# Rezoning Transportation Analysis

Petition Number: 2023-042

Date	Description
7-26-23	First Review (PM)
8-23-23	Second Review (PDM)
11-27-23	Third Review (JP)

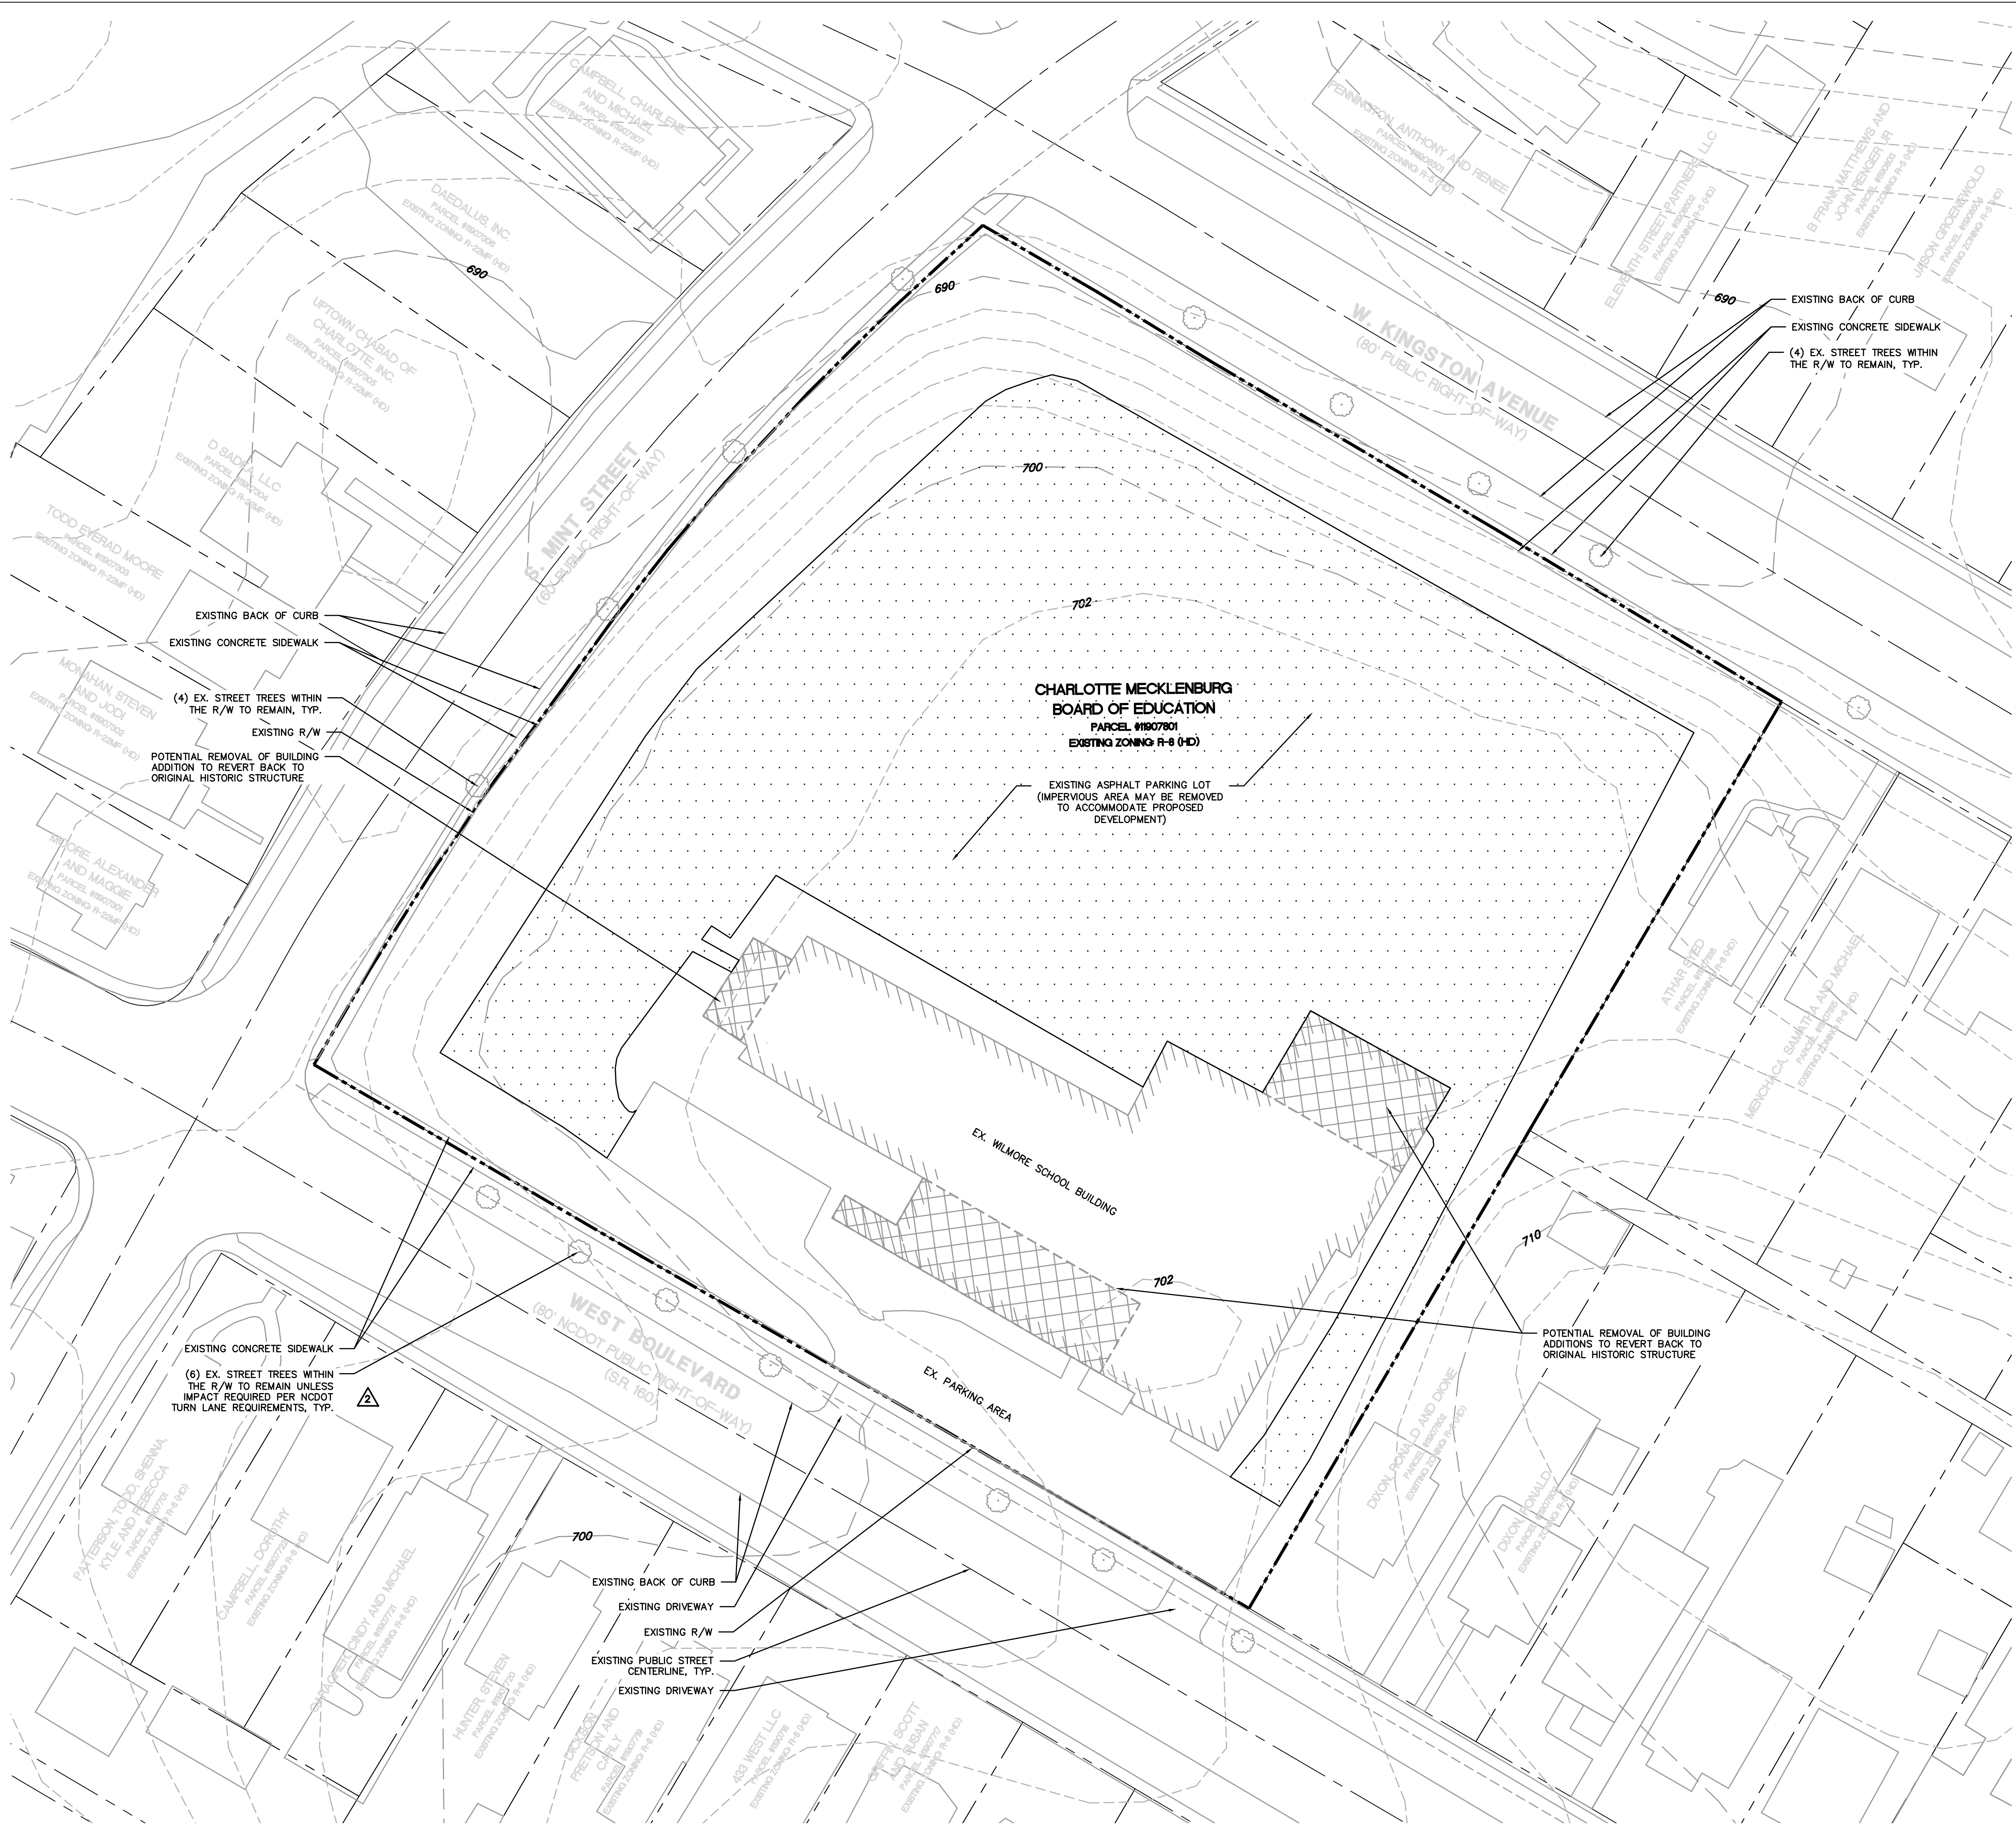
4. **Outstanding Comment from 7.26.23:** In coordination with NCDOT, revise site plan and conditional note(s) to commit to construct bicycle facilities by installing a 12' multi-use path on West Boulevard to meet the Council-adopted Charlotte BIKES Policy. Charlotte Streets Map calls for buffered bike lanes, NCDOT will not allow buffered bike lanes on West Boulevard. Multi-use paths maintained by the City shall meet ADA/PROWAG requirements.

**Clarifying Comment from 11.27.23:** Proposed streetscape is only 8'. Due to NCDOT not wanting a bike lane on their street, this needs to be a 12' shared use path.

5. **Outstanding Comment from 7.26.23:** Revise site plan to install the proposed streetscape off the future back of curb located 30' from the centerline.

7. **Outstanding Comment from 7.26.23:** Per coordination with NCDOT, the site access on West Boulevard needs to be right-in ONLY with a right turn lane.

- Clarifying Comment 11.27.23:** Revise site plan and conditional note to read, "Potential future driveway. Further coordination with NCDOT during permitting."
